**RE: University of Sydney, Campus Improvement Program 2014-2020
(SSD 13_6123) – Further Submission**

University of Sydney Campus Improvement Program 2014-2020

SSD 13_6123

Further Submission to NSW Planning and Infrastructure
25 August 2014

01 CITY ROAD ELEVATION - PROPOSED

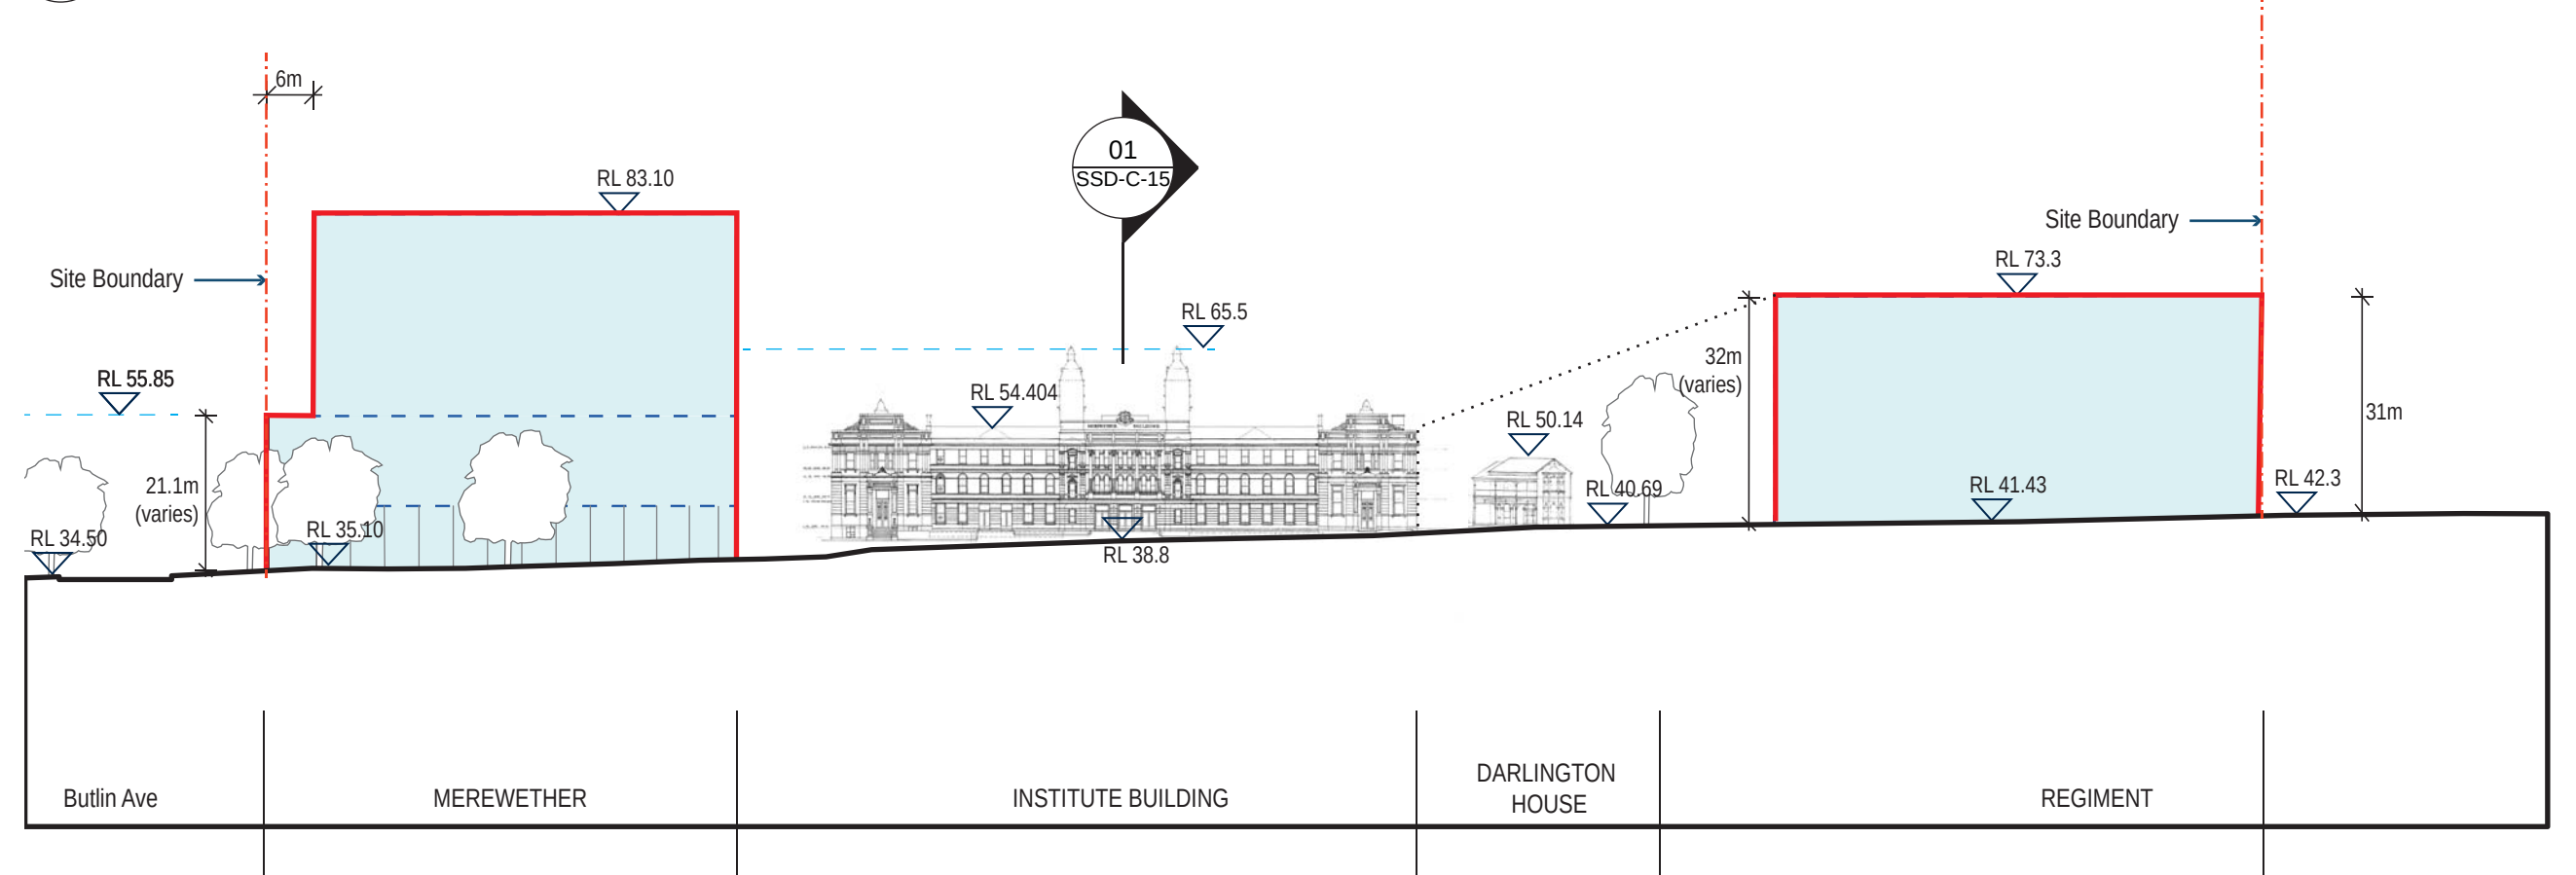
The height of the proposed Wentworth Building should be reduced to a maximum of RL65-RL67. The proposed envelope should also comprise a reduced street wall or podium height onto Butlin Avenue of RL53 and a setback of 6 metres onto City Road.

The University response retains the maximum height of RL83.10 and a podium of RL55.85 which are not supported. However, a setback of 6m from City Road has been adopted and a 6m setback from Butlin Avenue retained, which will aid pedestrian movement. The splay form resulting to the northern end of Butlin Avenue will enhance linkage to the Camperdown Campus.

The height of the proposed towers at the Wilkinson Building and International House should be reduced to a maximum height of RL65-RL67 and incorporate a setback of 5.5 metres onto City Road.

The University's written response refers to producing a 6 metre setback from City Road, yet the precinct envelope plans refer to "Nil Setback" in this area. Notwithstanding the previous recommendation to retain International House, the City supports the University's written response to provide a setback of 6m all City Road and recommended a setback of 5.5m to provide additional footpath space in its principal submission. An increased setback, commensurate with that proposed for the Wentworth Building further to the west, will allow for increased pedestrian usage and the provision, protection and retention of street trees. The plans should be amended to provide this setback.

01 ENGINEERING - SHEPHERD STREET ELEVATION PROPOSED

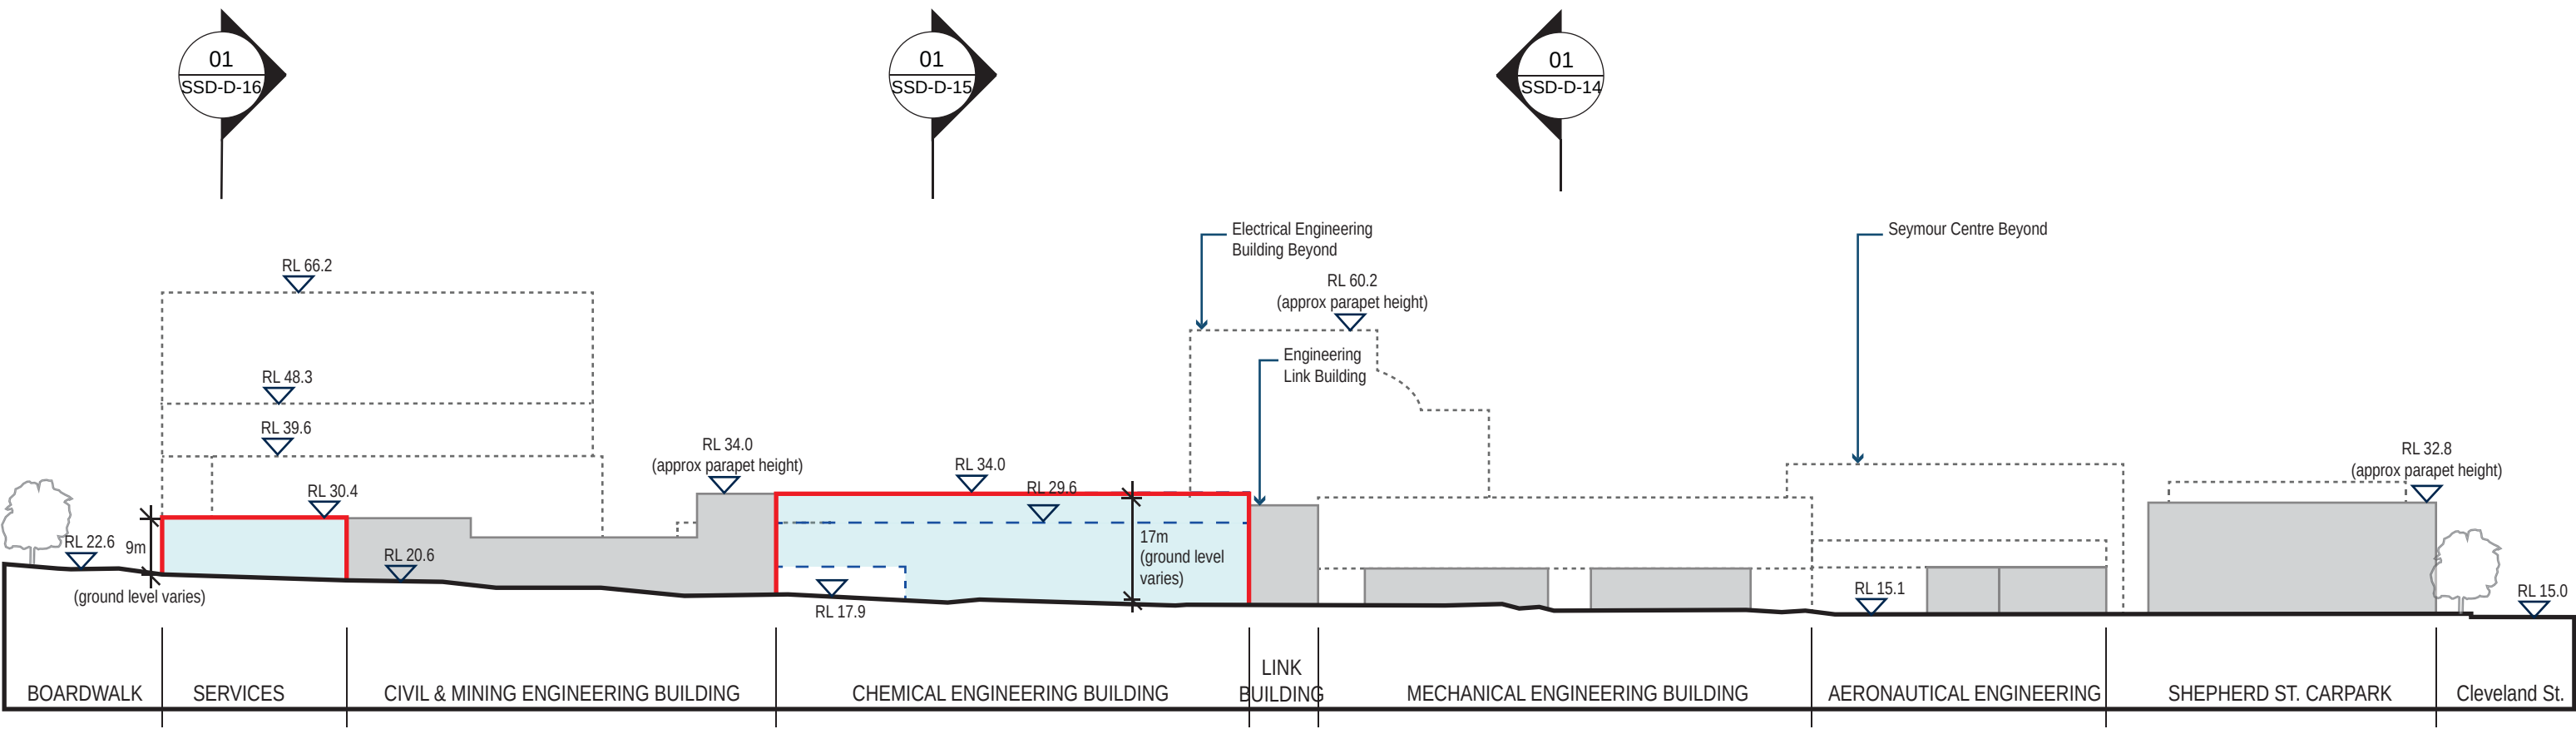
The University acknowledge this in the written response, yet retain the envelopes to the same height as the ridge of the existing terraces. In order to maintain the setting of the terraces, and minimise overshadowing and privacy impacts, these heights should be lowered to equate with the eave/ gutter heights, rather than the roof ridge heights, approximating to RL 45.0 at the southern end falling to RL 39 at the Codrington Street/Butlin Avenue intersection.

Issues of separation in terms of privacy, overlooking and shadowing are inadequately addressed in the position of this envelope. The shadow diagrams presented in the CIP would suggest that the envelope receives little to no solar access to the northern elevation due to its proximity to the rear of the existing terraces.

01 LIFE SCIENCE - PROPOSED ENVELOPE PLAN

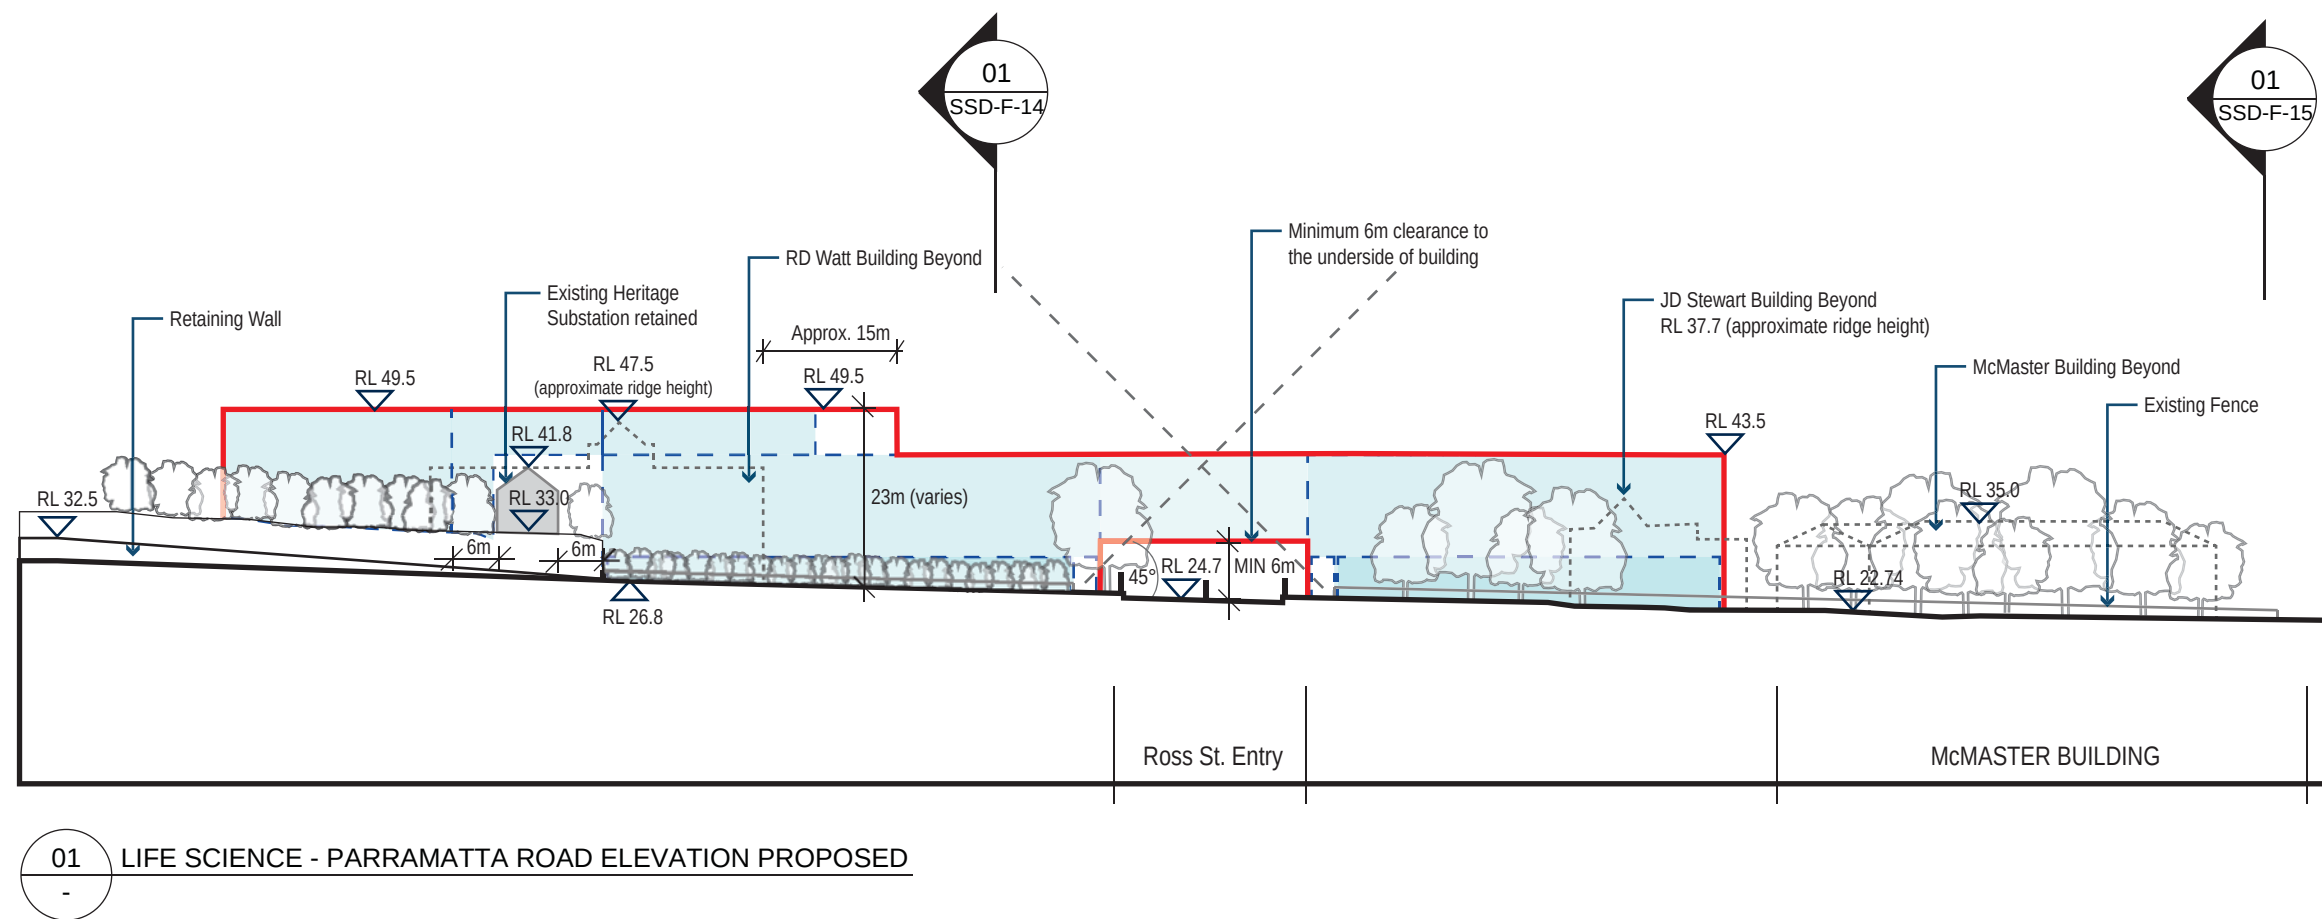
The southern extent of the proposed building west of the Ross Street gates (Envelope 1) should be reduced and a setback for the envelope from Parramatta Road established behind the line of the sandstone pillars of the Ross Street Gates.

In the University's response the building footprint has been revised to be set back from Parramatta Road and the height of this western element reduced, which are positive changes in response to the recommendation in the City's principal submission. However, the envelope extends forward of the sandstone gate pillars towards Parramatta Road, which is strongly opposed.

The southern extent of Envelope 1 is not supported as it will block views of the significant JD Stewart Building from the Ross Street entry and impact on its visual curtilage. The southern extent of Envelope 1 should be reduced as shown on the sketch (page 36) of the City's principal submission.

Drawing Title:
LIFE SCIENCE - PARRAMATTA ROAD
ELEVATION PROPOSED

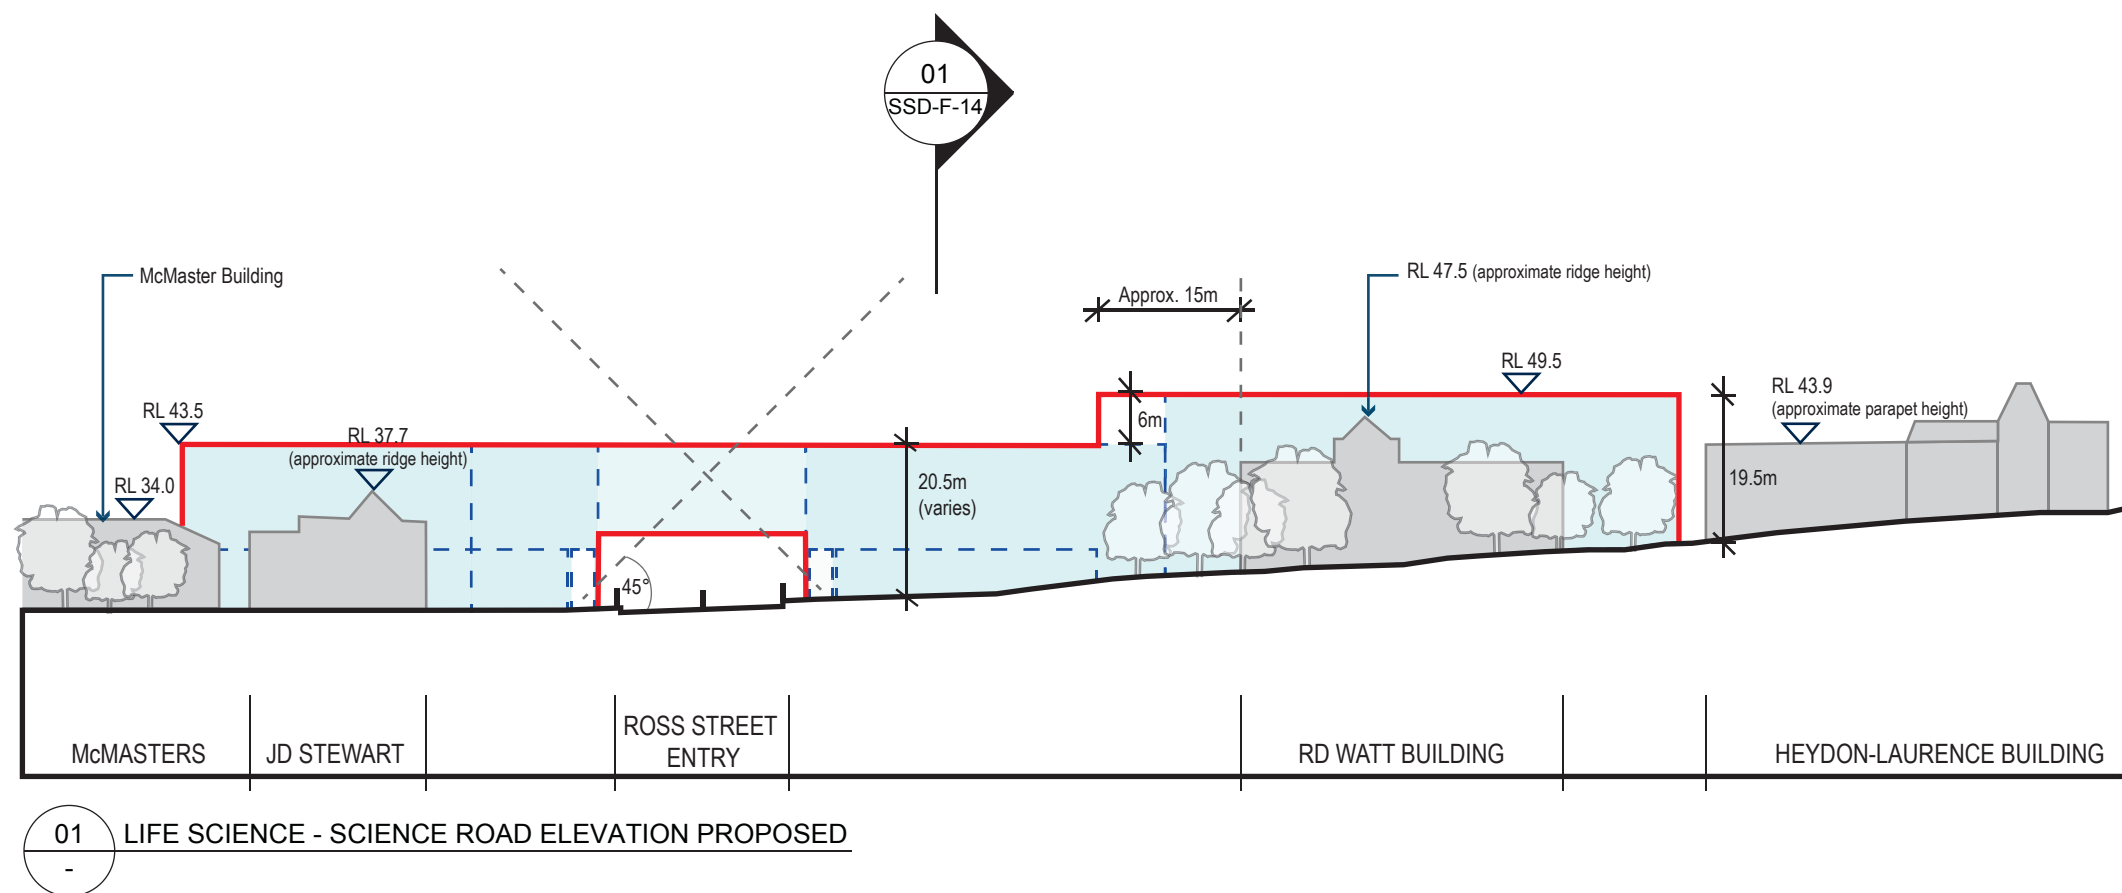
The height of new buildings east of Ross Street gates should be lowered such that it is no higher than the main ridge of the RD Watt Building (RL40). As per the previous recommendation, a setback for the envelope from Parramatta Road should be established behind the line of the sandstone pillars of the Ross Street Gates. The section of building in between the RD Watt Building, the substation and Hayden – Laurence building is not supported. The location and size of the McMaster Building western addition should be reconsidered in light of CMP prepared for the building.

In the University's response Envelope 2 has been setback from the Parramatta Road frontage at the western and eastern ends and has been lowered by 6m between the Ross Street entrance and western curtilage of the RD Watt Building, which are both improvements. However, the setback of the building footprint from Parramatta Road should be continuous and not protrude to the Parramatta Road boundary just west of the substation. The proposed envelope should not extend forward of the sandstone pillars of the gates. A continuous setback will ensure the retention of the character of the University, where buildings, apart from gate houses, are setback from perimeter boundaries.

01 DARLINGTON TERRACES - PROPOSED ENVELOPE PLAN

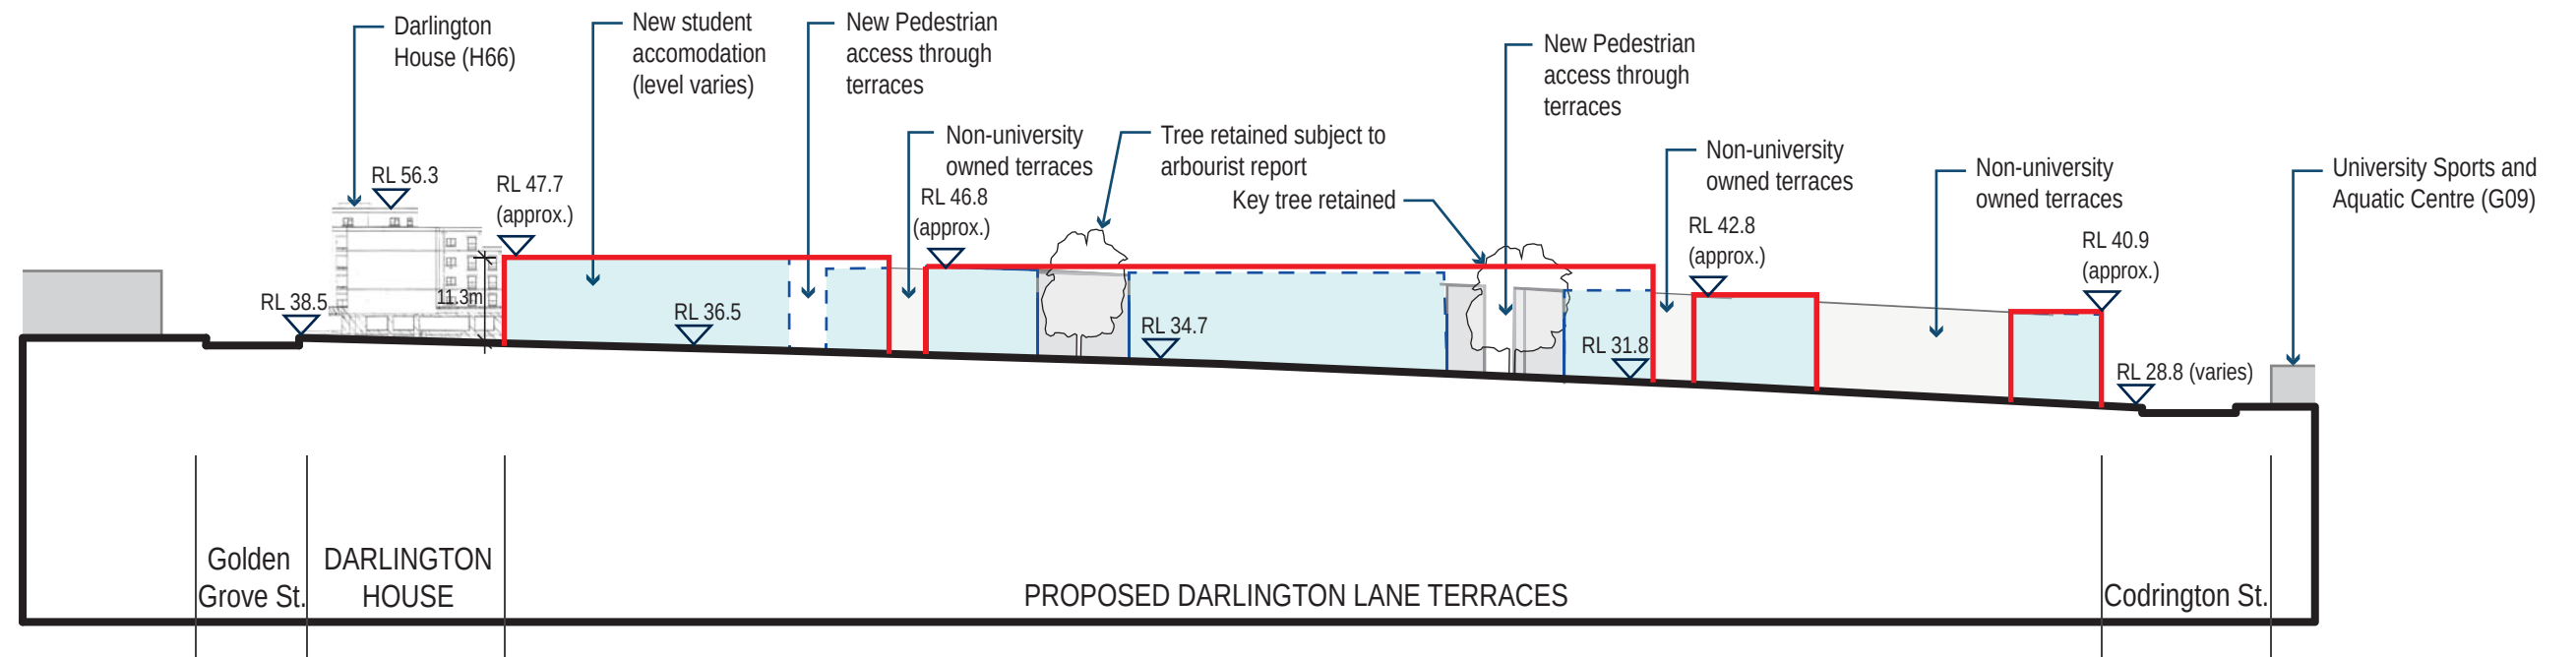
Development to the rear of the terraces on Darlington Street (Envelope 3) should be subservient to the scale of the terraces at the street frontage. Options for adaptive reuse of the terraces should be considered prior to establishing whether additional floor space is appropriate.
